ASDA Ferring PFS - Drainage Information for discharge of conditions

Laura Gibbons requested further information on several points with responses given below by Paul Gill (Adept Consulting Engineers Ltd):

Typical detail cellular attenuation tank

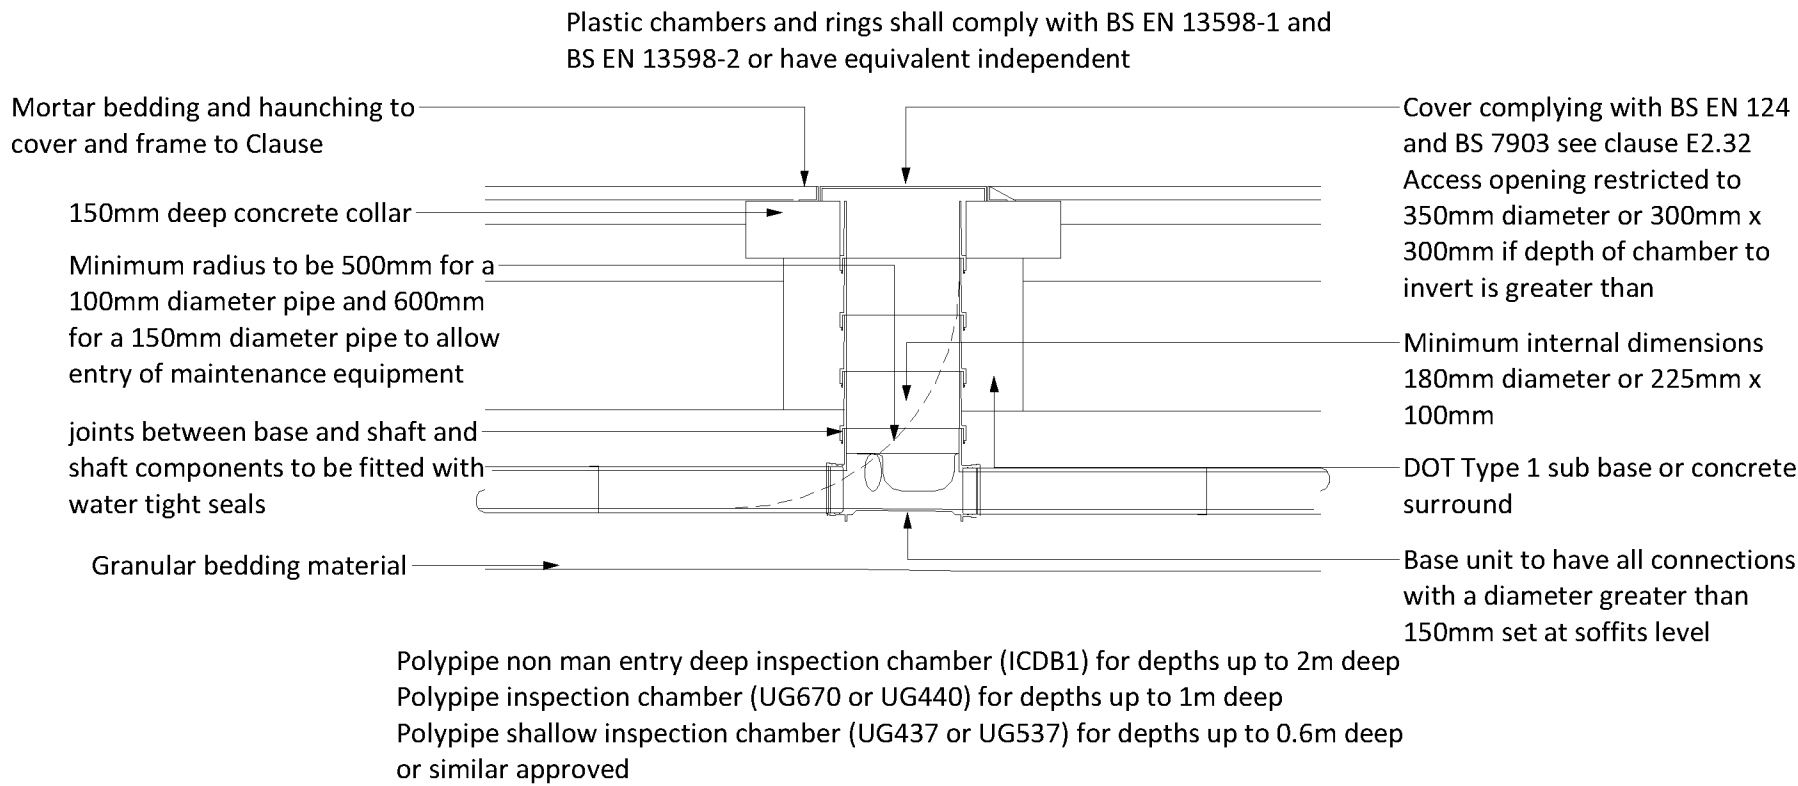
- 3. The original calculations I was supplied with were presuming the Hydrobrake was 5l/s. Please provide revised calcs for 2l/s that show that the proposed Alderburgh tank is sufficient to hold the 1 in 100 year event plus 30% climate change.*

We have previously forwarded to our planning team revised calculations for the 2 l/s Hydrobrake and again forward these for completeness. This shows the total amount of attenuation which is needed to be stored e.g. 162m³ and we have provided 191.4m³ of attenuation in the form of the attenuation tank and by reutilising some of the existing porous subbase on site – where development is not taking place and the site is being left as existing conditions.
